KIRKLEES METROPOLITAN COUNCIL INVESTMENT & REGENERATION SERVICE

DELEGATED DECISION TO DETERMINE PLANNING APPLICATIONS

Reference No:	2024/62/91778/W
Site Address:	28, Rafborn Grove, Salendine Nook, Huddersfield, HD3 3UB
Description:	Demolition of existing outbuilding and erection of single storey wrap around extension with associated alterations
Recommending Officer:	Molly Storer

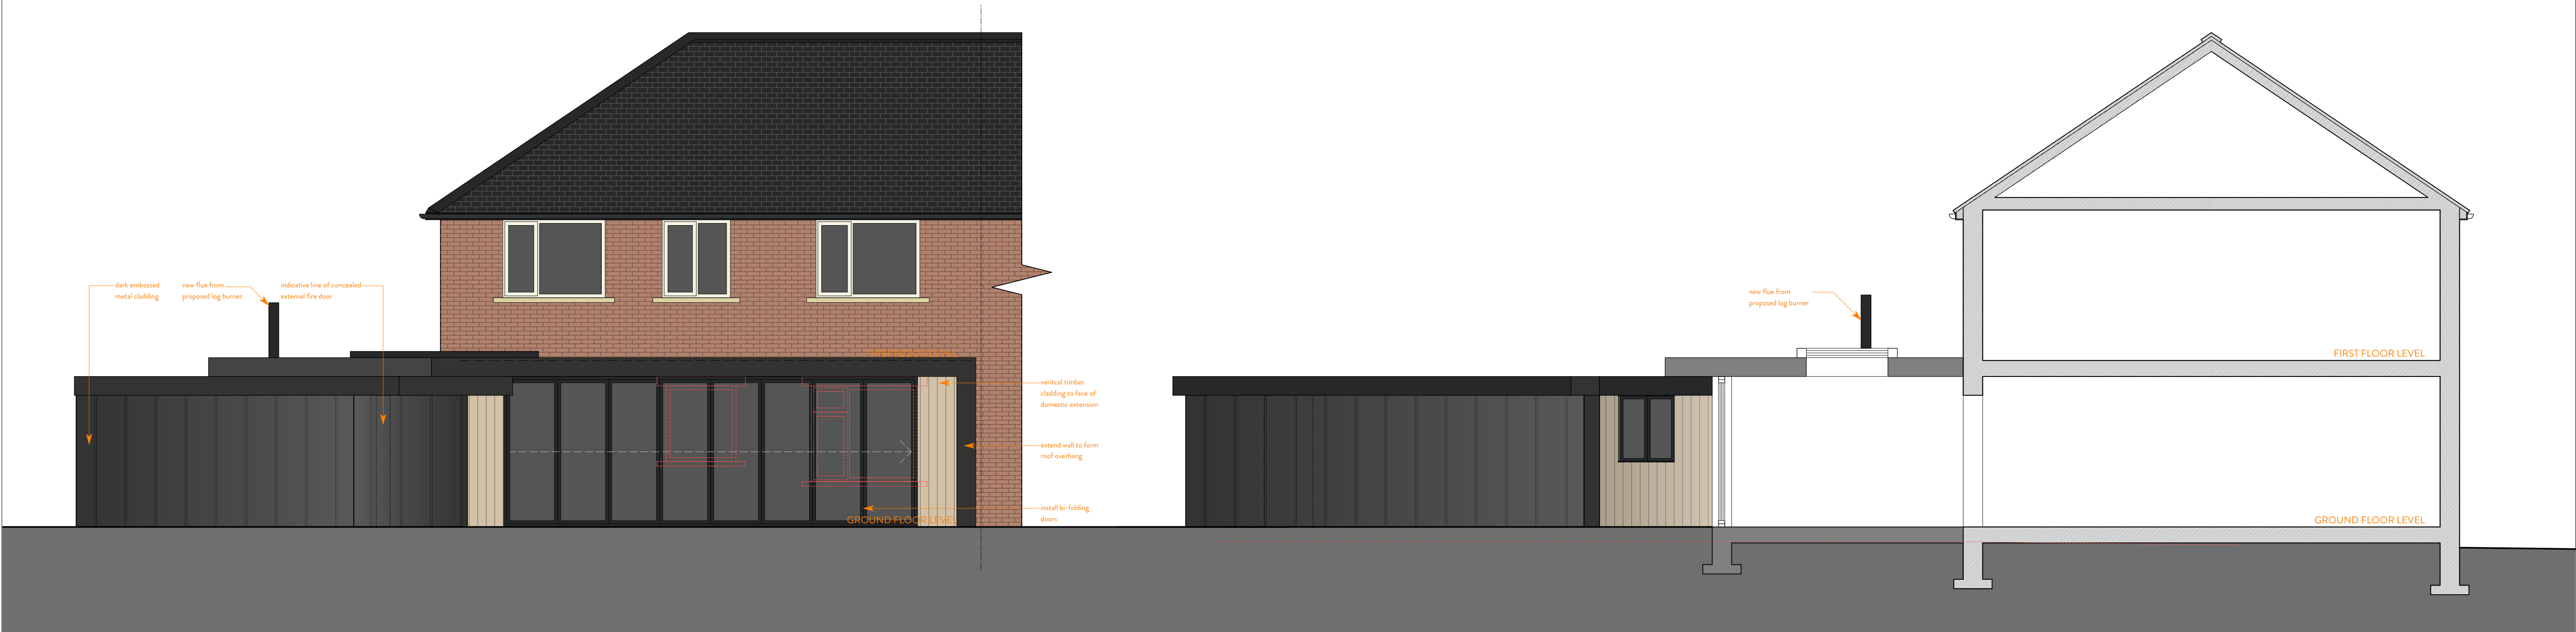
The extension would be located on the shared neighbouring boundary with no.30, Rafborn Grove. Although contrary SPD guidelines, it is considered there would be no visual design benefit in setting the extension in by a metre due to this property also having an extension which is built on the boundary. The dwelling is semi-detached and although the rear element would not exceed 4 metres in height it would project 4.75m meaning it would not be SPD compliant.

The side extension would match the rear extension and host dwelling in terms of materials used, being constructed from brick and timber cladding. The extension would not exceed a height of 4 metres. The roof would also follow on with a flat roof design.

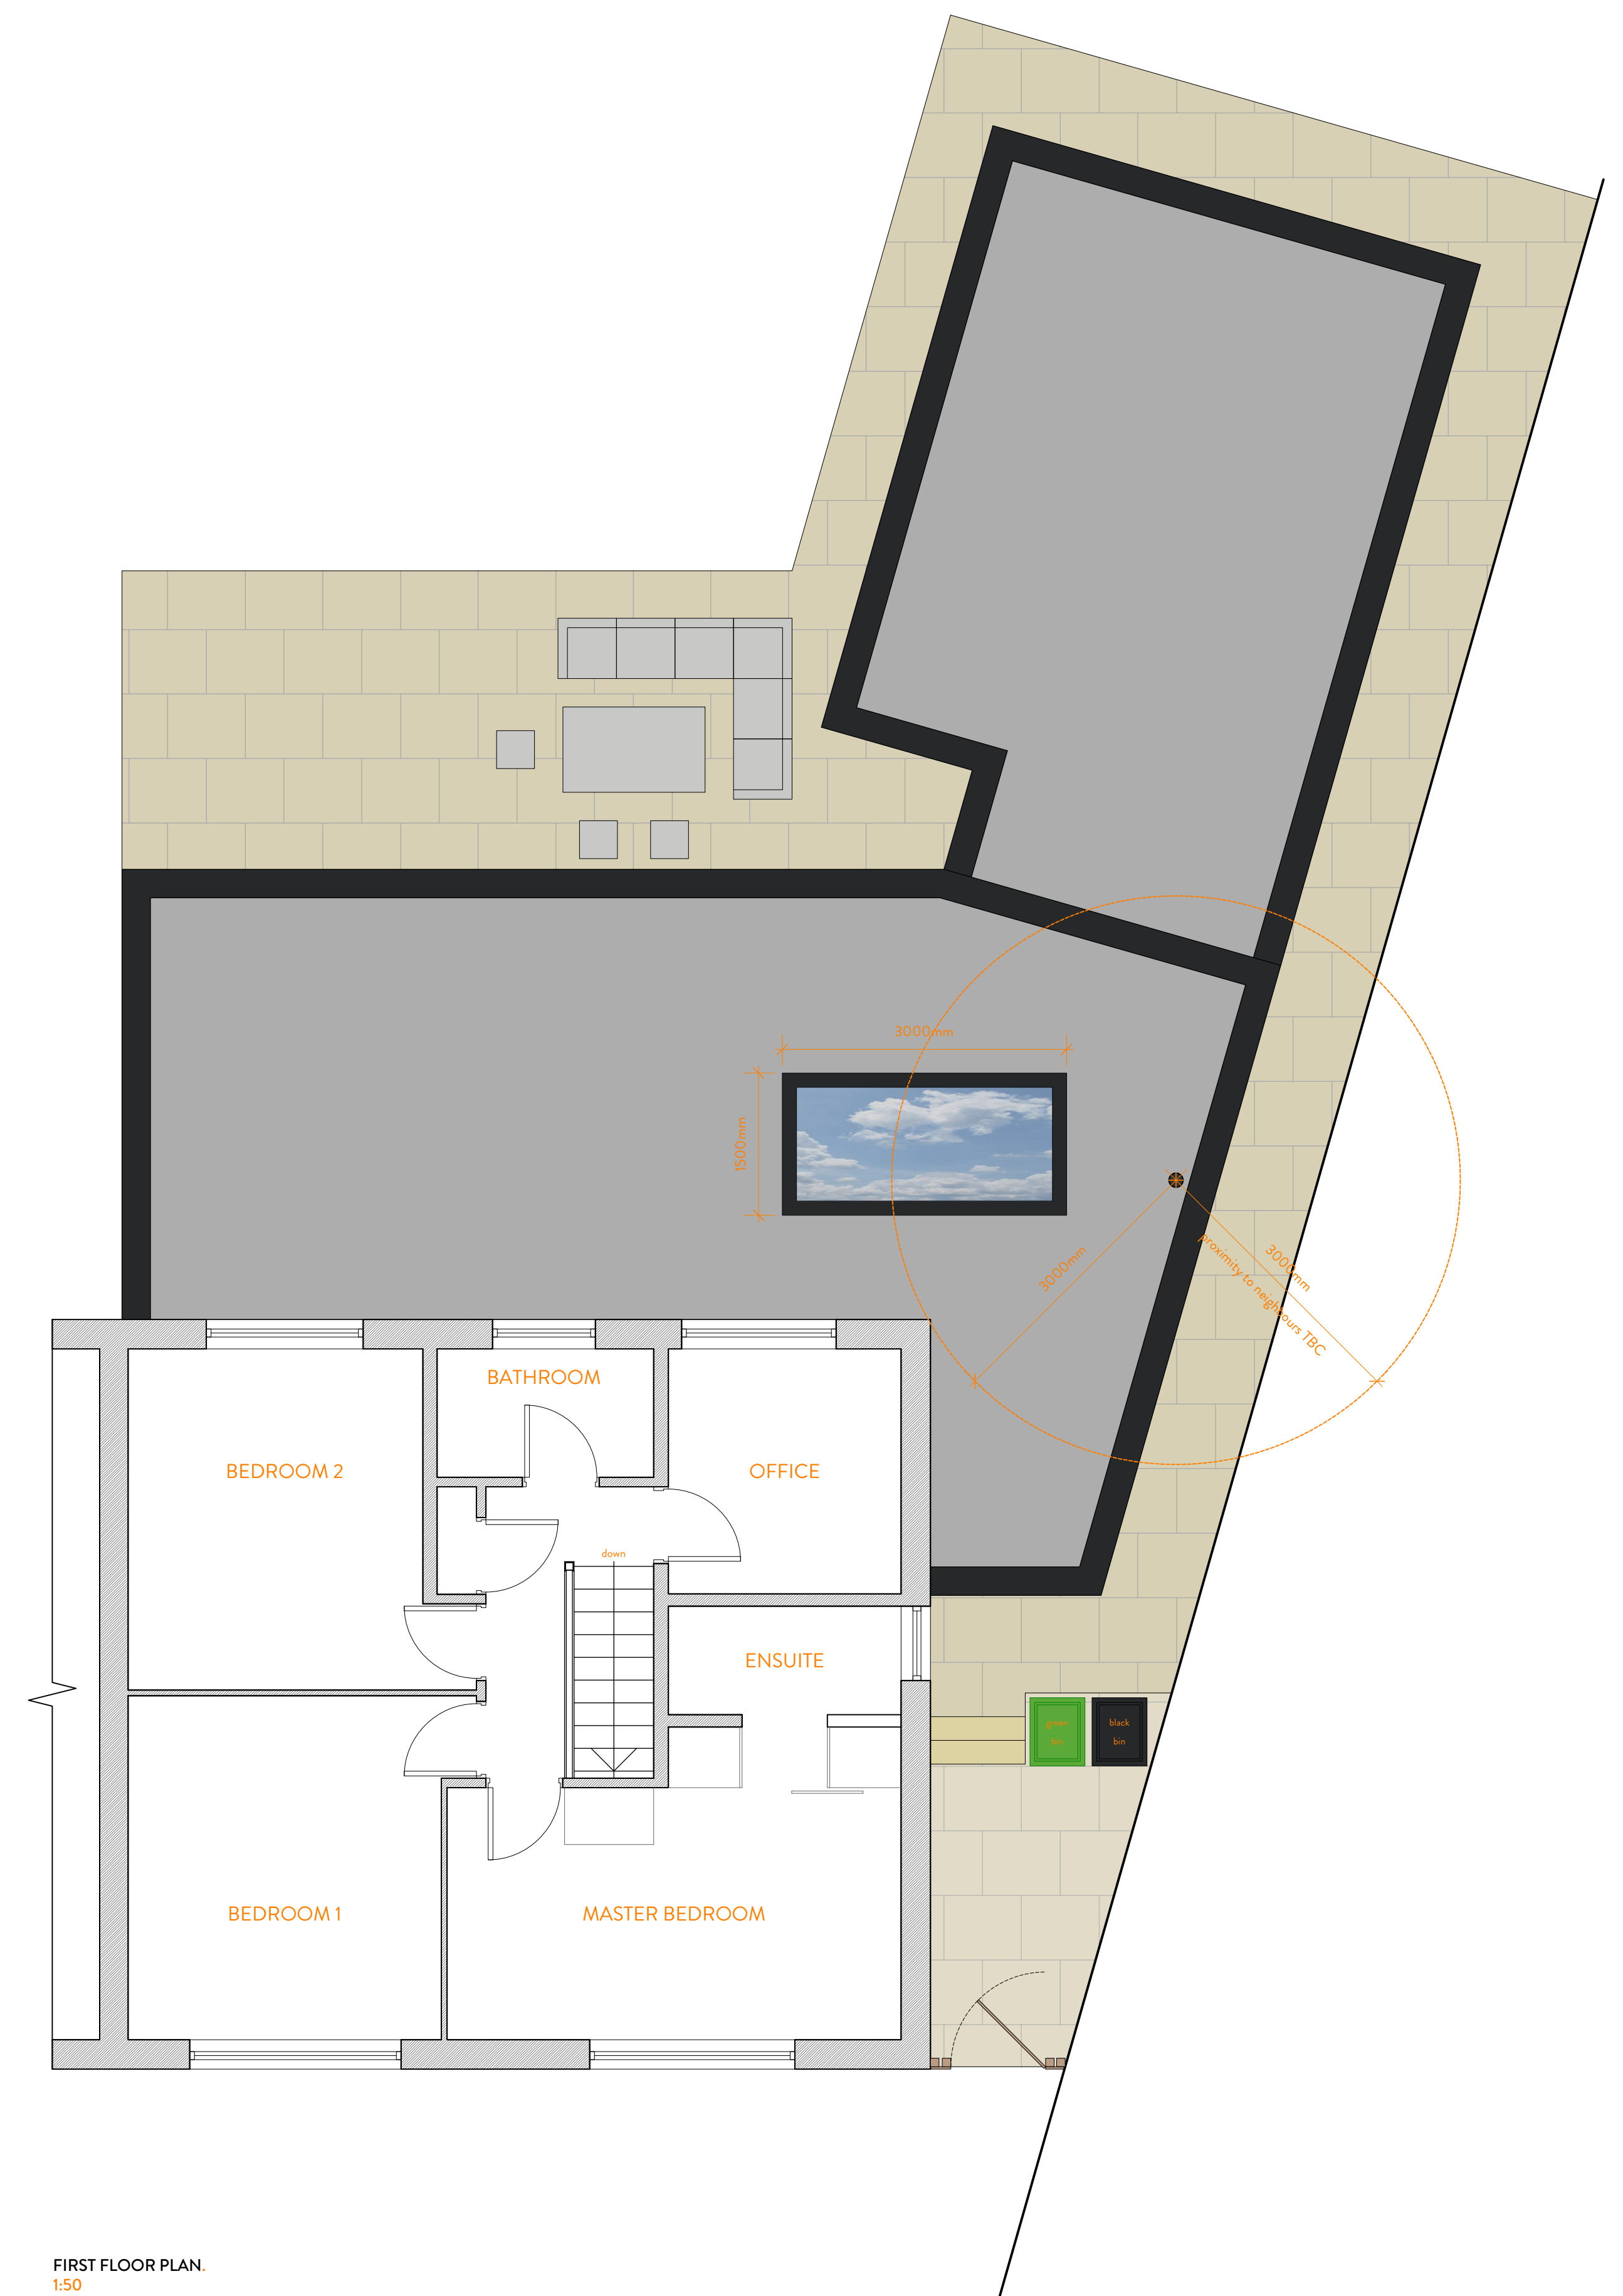
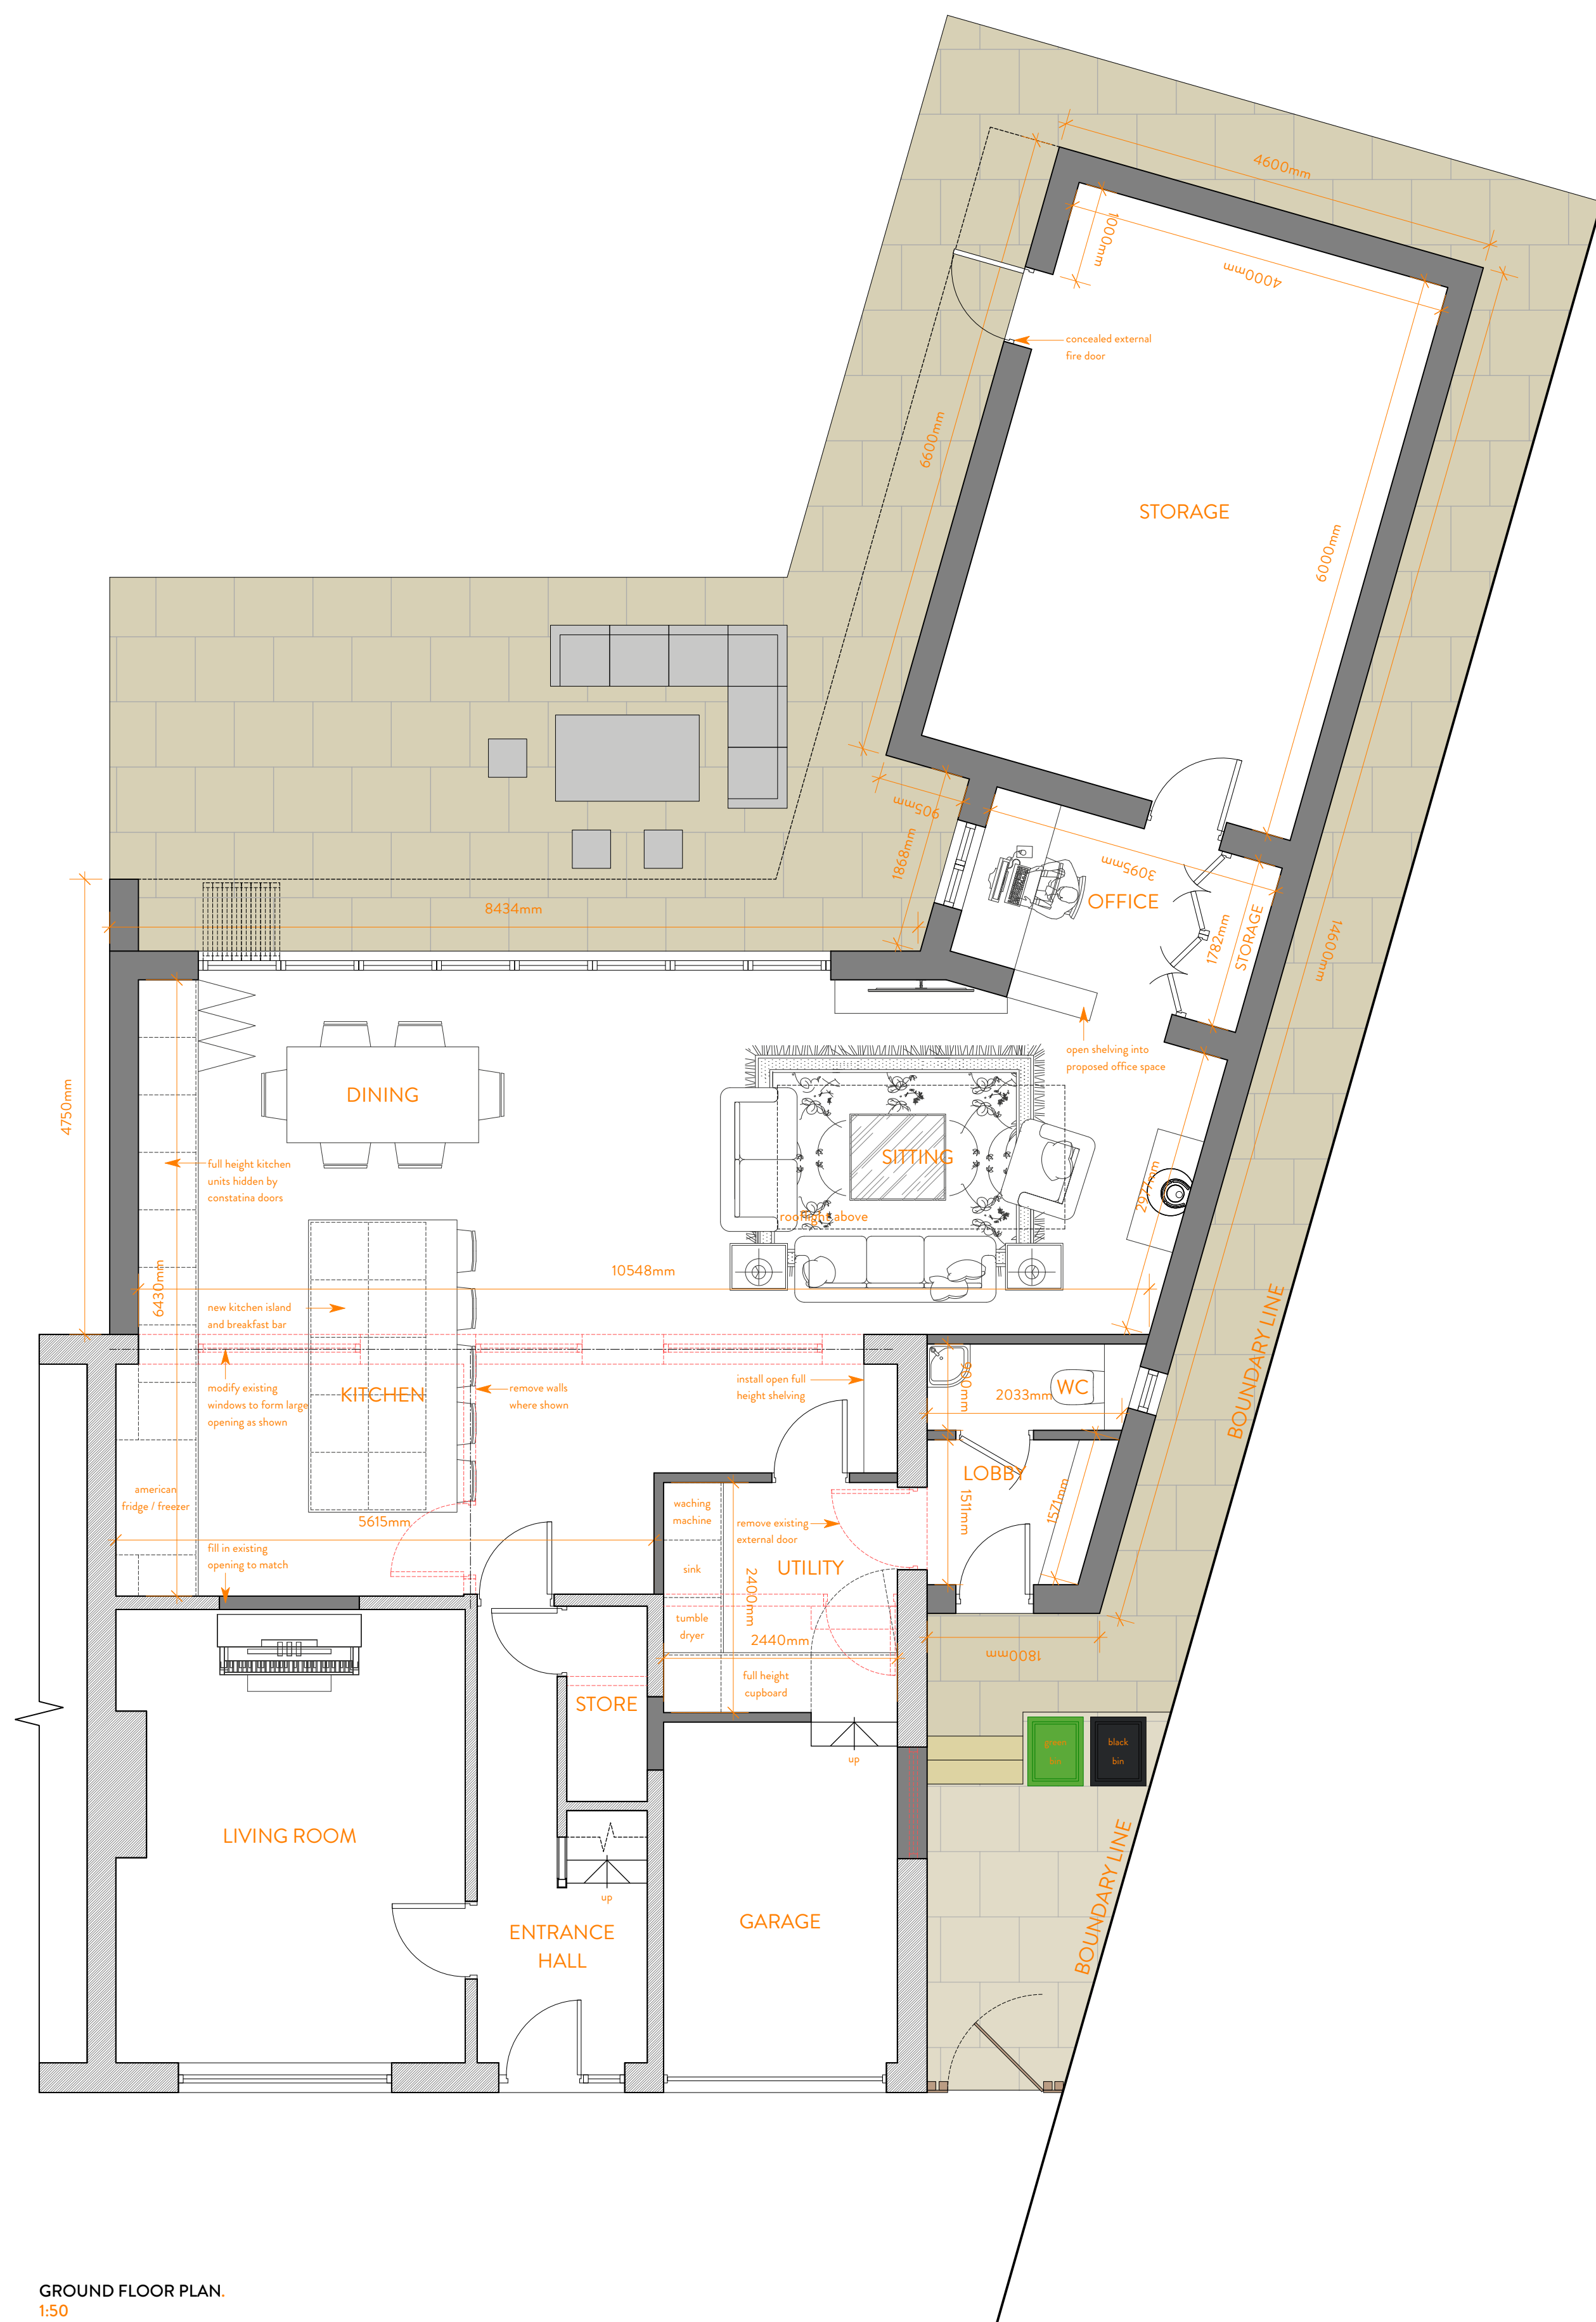
26 Rafborn Grove is a semi-detached dwelling located to the east of the application site. The wraparound extension would have a single window within the east-facing elevation which would directly face this dwelling. This window on the submitted plans is shown to serve a bathroom however given the proximity of the extension to the shared boundary (1m), it is recommended that this window be conditioned to be obscurely glazed to retain the privacy of this neighbour.

3. The development shall not be occupied until the window within the eastern (side) elevation of the extension hereby approved have been obscure glazed (minimum grade 4). Notwithstanding the provisions of the Town and Country Planning (General Permitted Development) (England) Order 2015 as amended (or any Order revoking or re-
